January 5th, 2024

Re: Letter of Concern 3 regarding Kittitas County Conditional Use Application CU-23-00001

QUESTIONS AND CONCERNS REGARDING KITTITAS COUNTY CU-23-00001

**3BR CUSTOM CUTS  
PROCESSING PLANT**

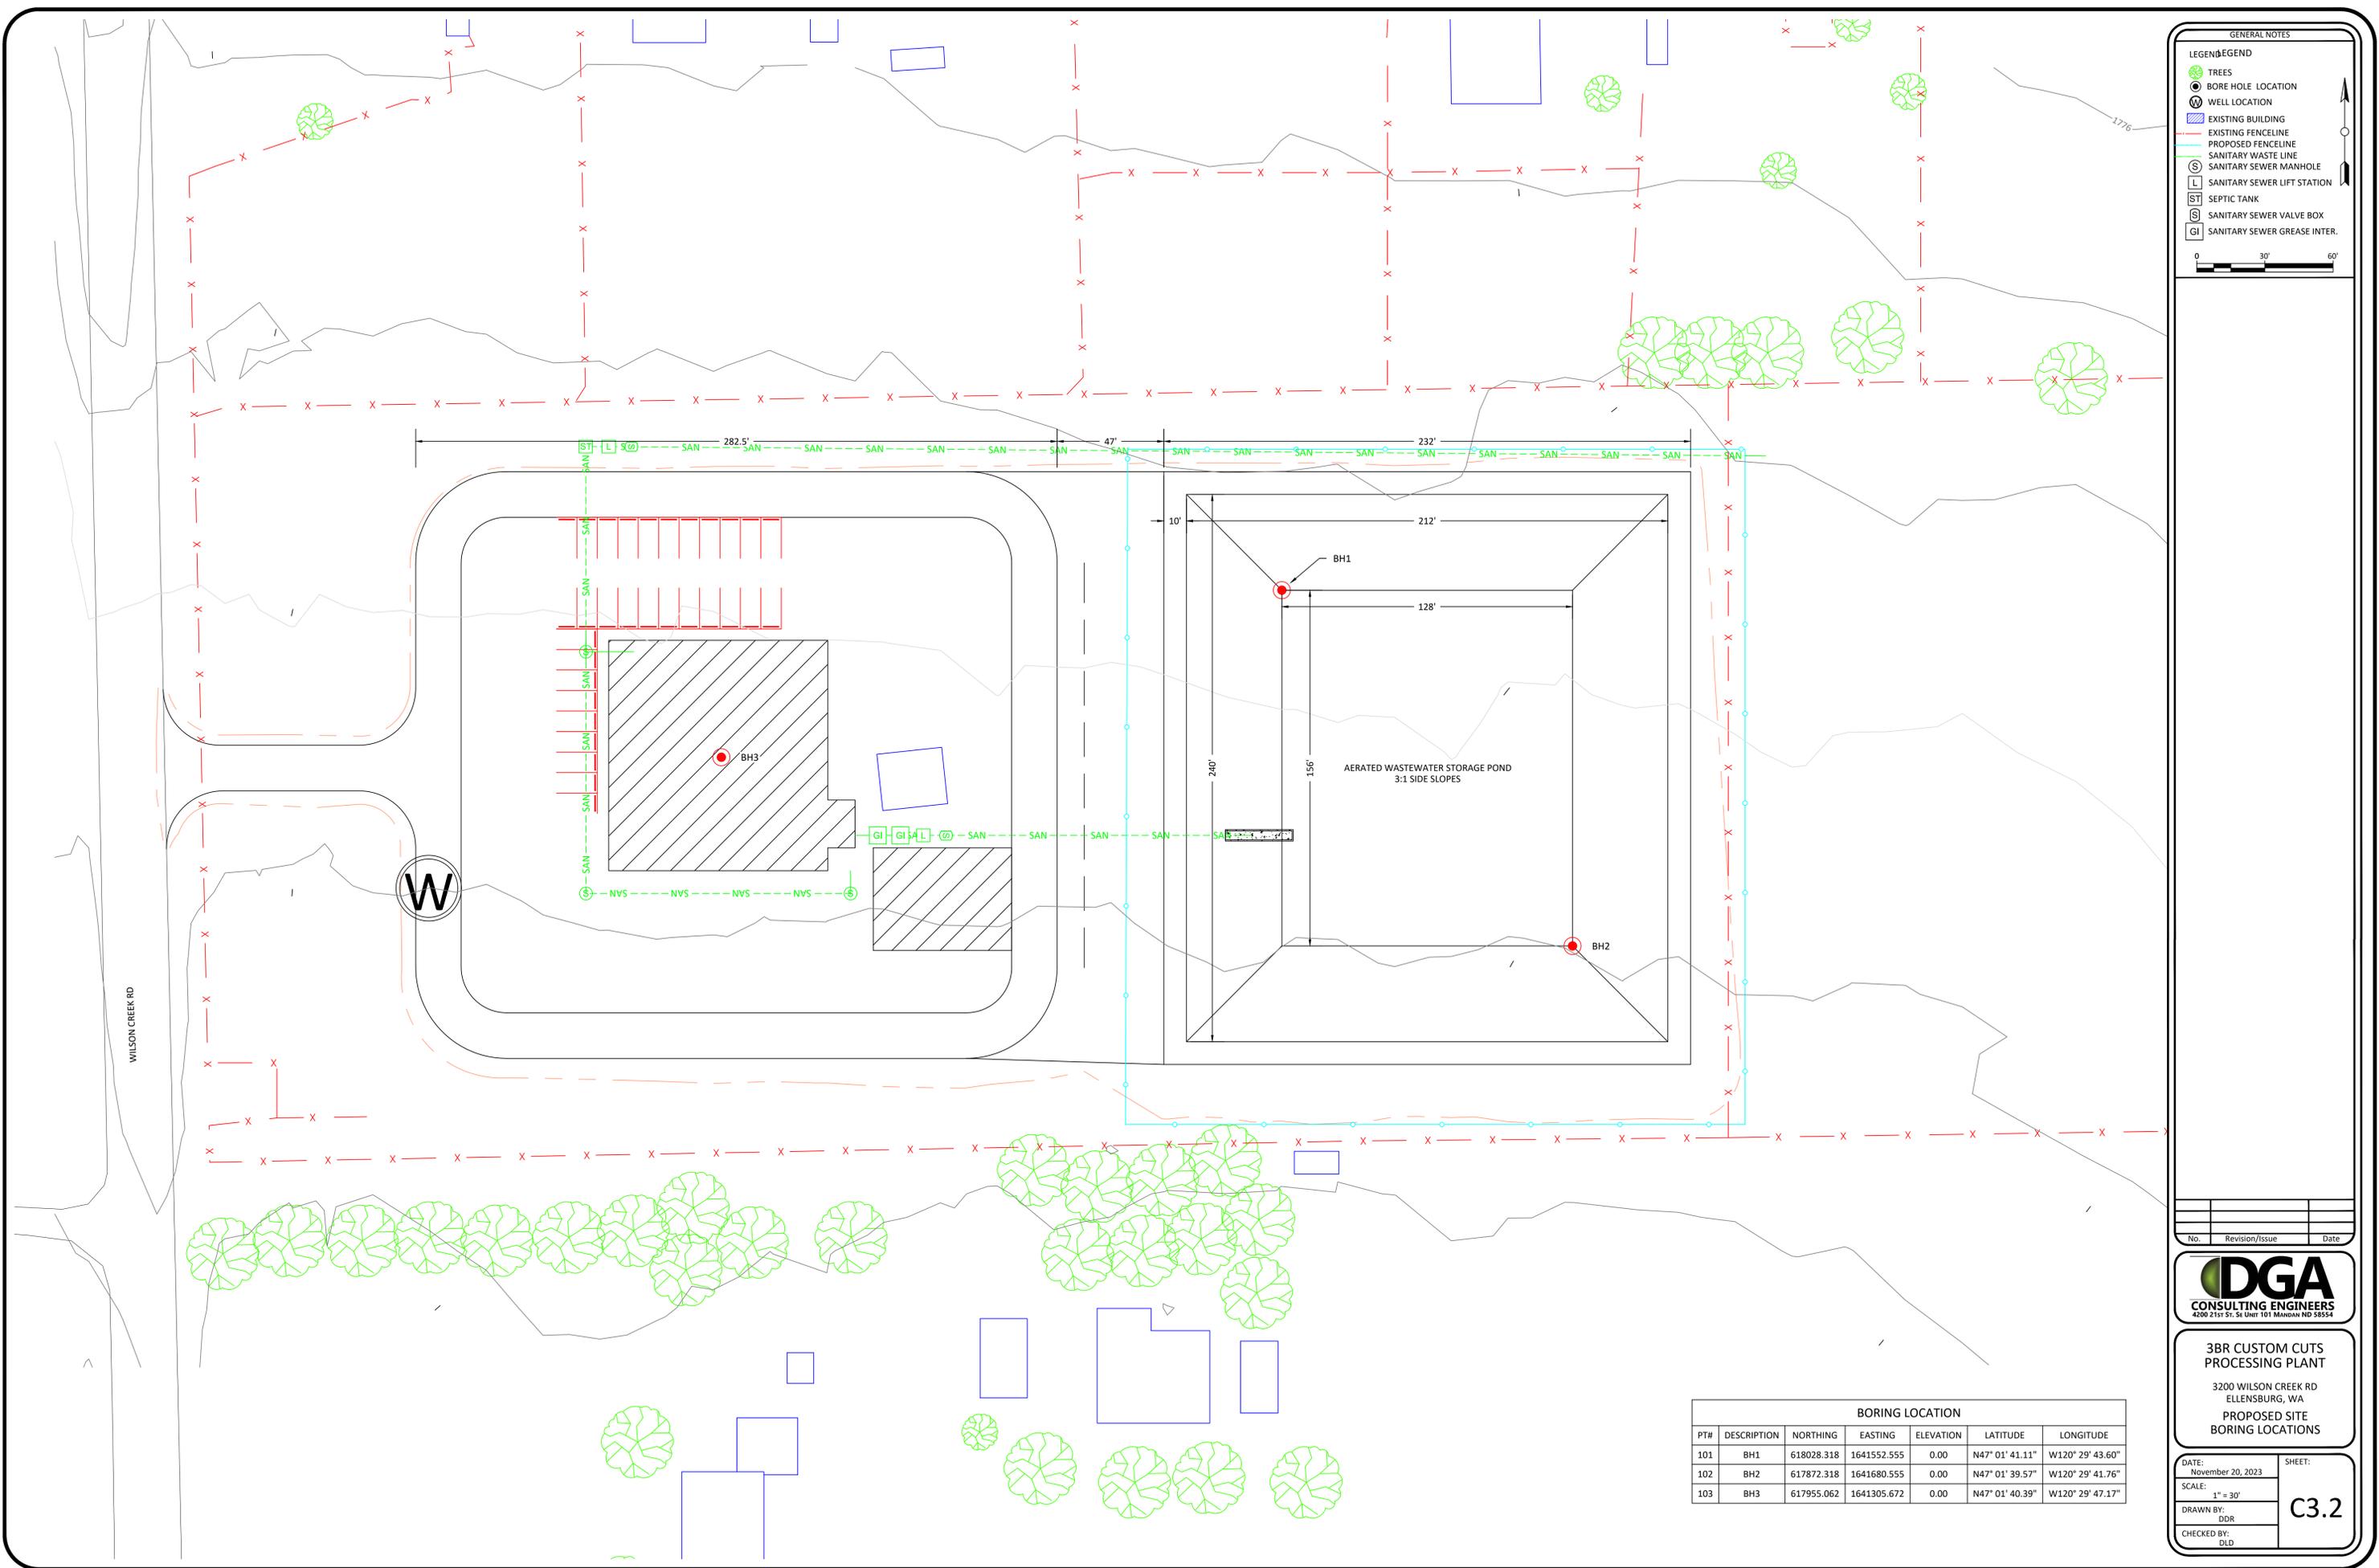
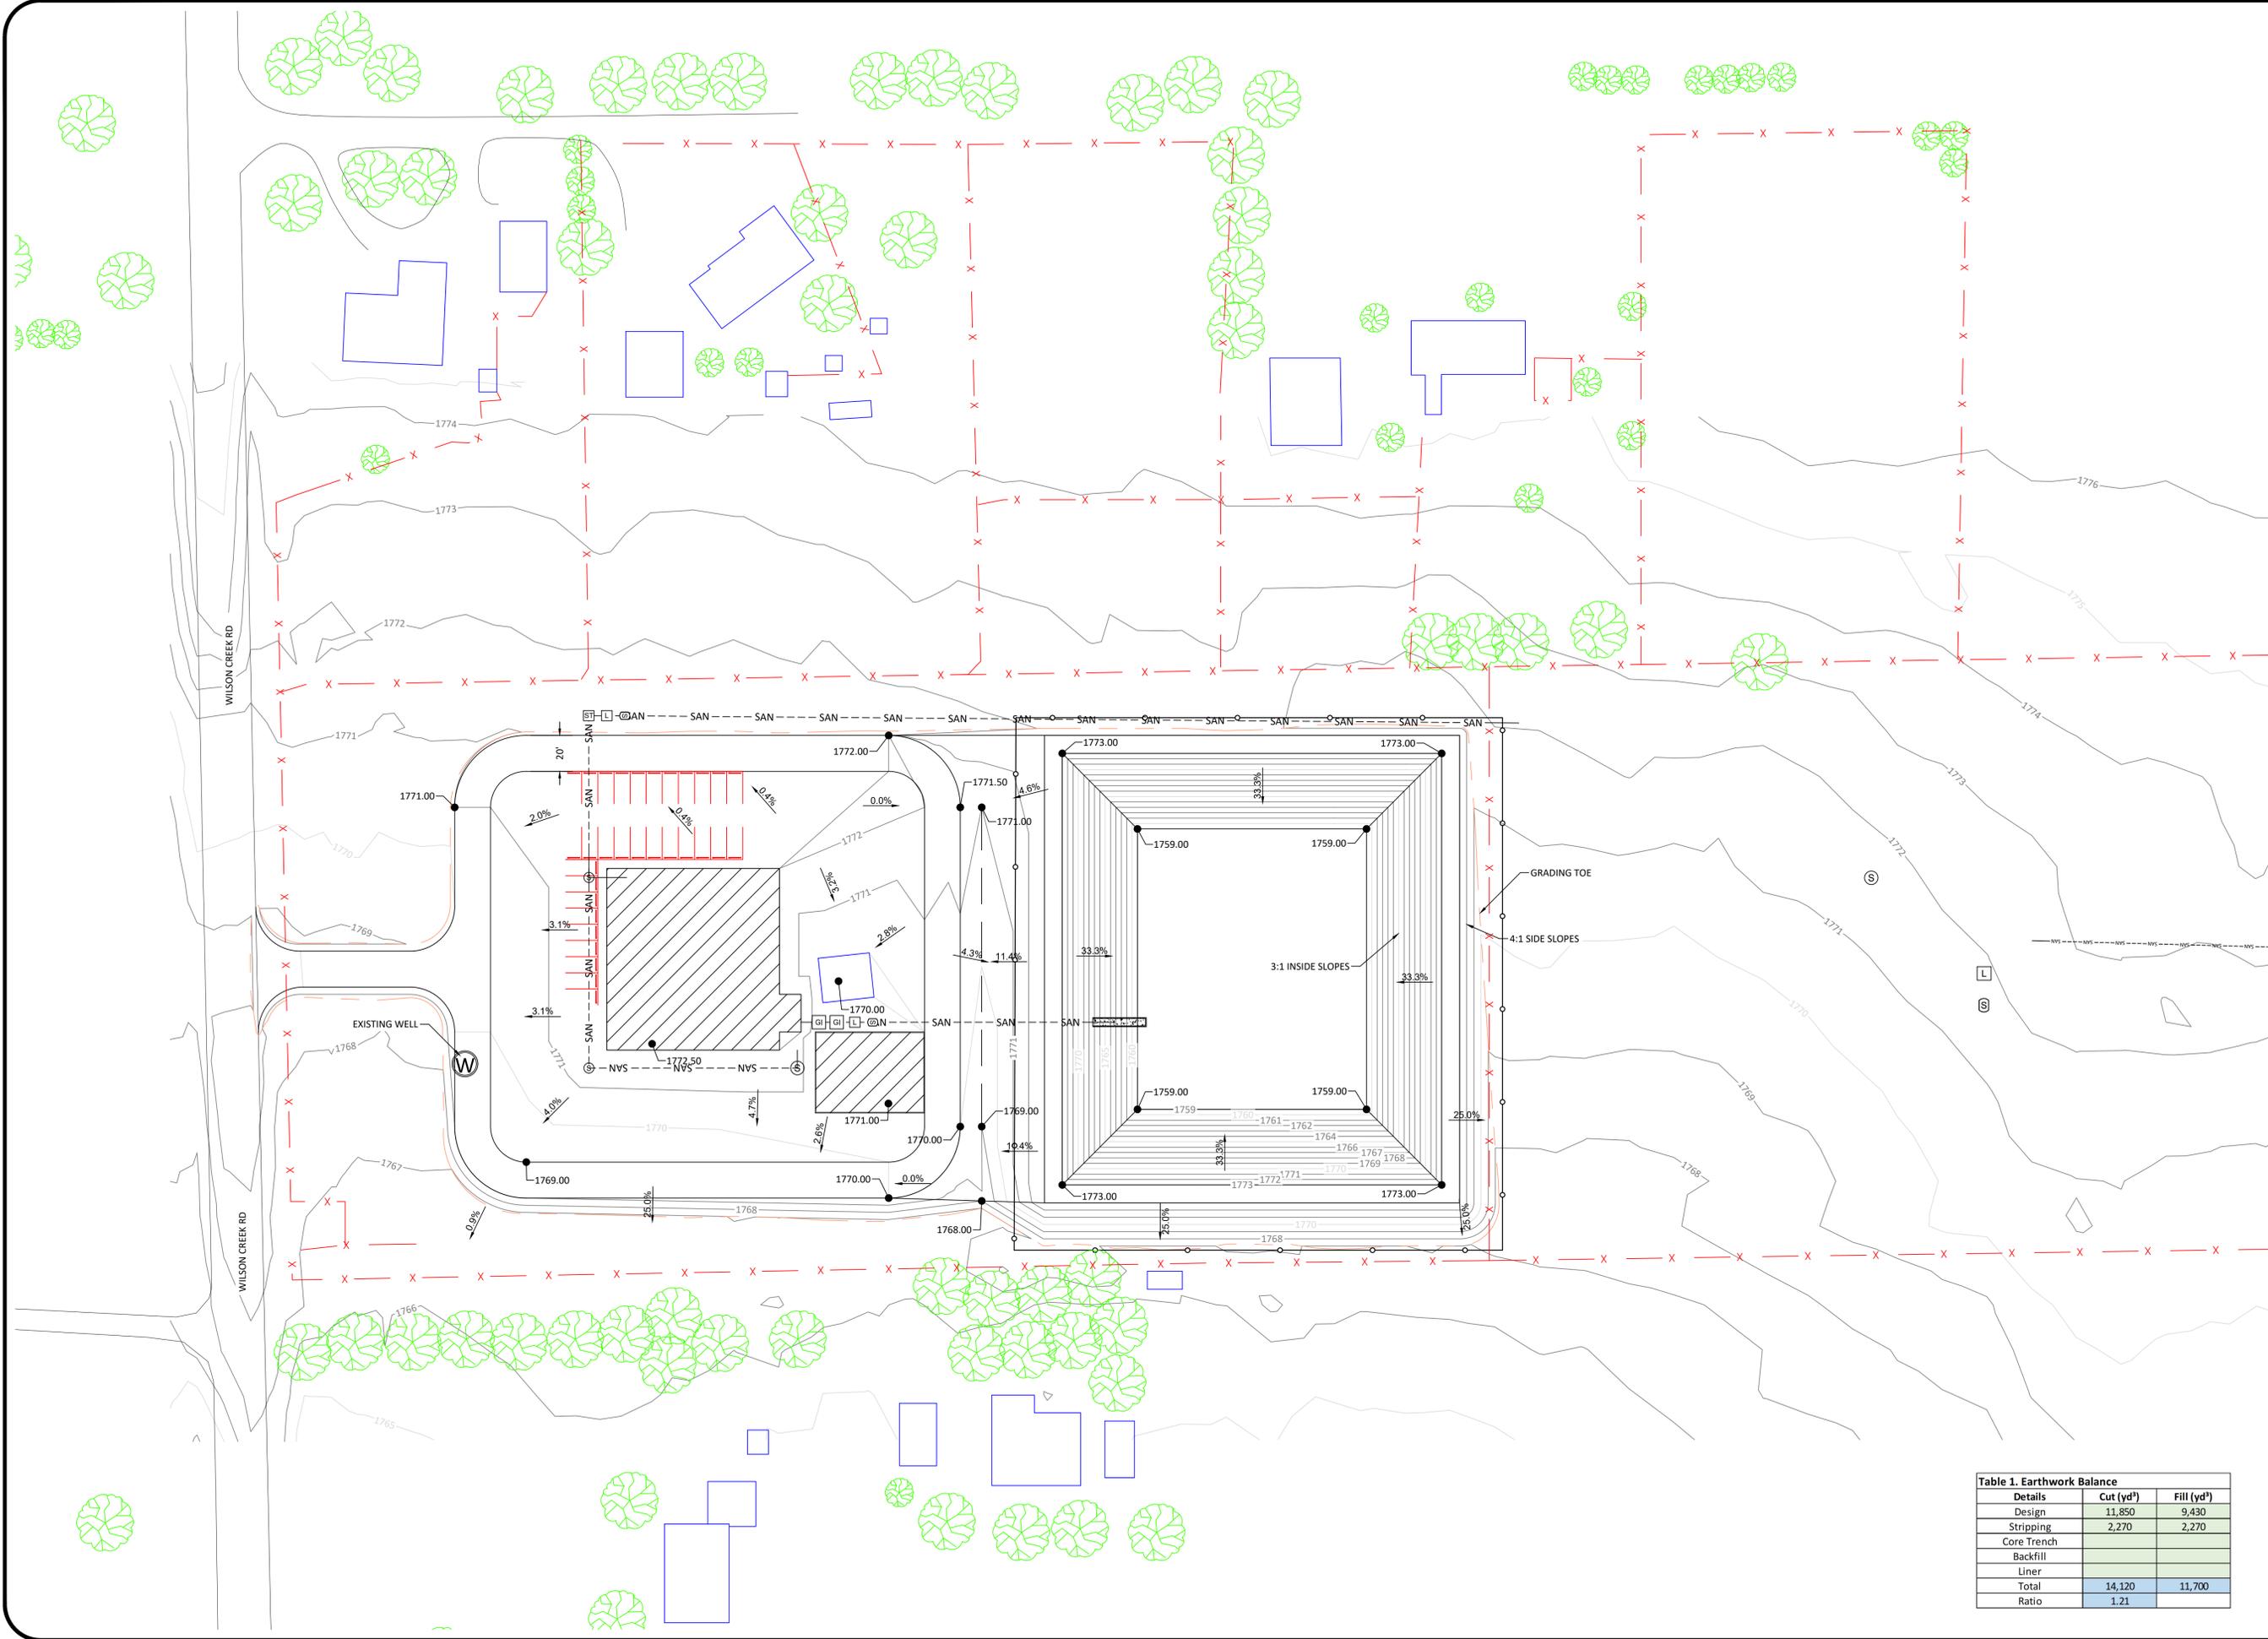
Concerns about the effluent from the aerobic pond being sprinkled on the site—will it contaminate ground water (particularly during times of seasonal flooding where it is likely to flow into Lyle Creek), will the spray be carried in the wind to adjoining properties and potentially contaminate them?

"[...] an aerobic pond(s) may generate bad odours. It is thus important to locate the ponds far from settlements."⁷ While this site has a small footprint compared to Schaake's it is in no way insignificant—it is extremely close to residential properties and the waste associated with meat processing takes substantially longer to break down than animal feces.

Concerns regarding the diversion of water from the large footprint of aerobic pond.

This area is prone to significant seasonal flooding as witnessed last spring, the diversion of any groundwater is likely to divert potentially contaminated water to neighboring properties and into Lyle Creek. We are also concerned that this seasonal flooding potentially impairs the function of the aerobic pond?

The aerobic pond is a sewage treatment plant for potential contaminants. The plant area, parking lot, holding pens, and aerobic pond are all densely packed at the western portion of the property adjacent to the public road in the manner of industrial property. The aerobic pond/waste treatment pond is of significant dimensions related to the north south boundaries of the property which the Kittitas County Assessor's Property Map depicts as 317' at the west boundary (it is unclear from the diagram provided within the reapplication but the size of the aerobic pond appears to be 240' from north to south allowing for a mere 38.5" to be divided for a scant buffer between the adjacent properties to the north and south of the site (the diagram does not clearly denote the distance from the pond to the property boundaries on the north and south). It appears the aerobic pond is closer to the northern boundary of the property, and it is unclear whether there will be room for trees at the northern side of the aerobic pond. A fence and trees will not cure the blight that this facility would be to the visual and natural

landscape to our neighborhood. Furthermore, trees and their roots could present a risk to the integrity of the pond liner. This configuration seems totally contrary to the “rural character of the neighborhood” and is in no way equivalent to grazing cattle which enhances the rural character—it amounts to a conversion from Ag-5 to Industrial zoning.

Wilson Creek is a 50mph zone adjacent to this site. A modest sized stock trailer is forced to enter and block oncoming traffic to make a right angle turn as noted in the site plan included within this reapplication posing a public safety hazard.
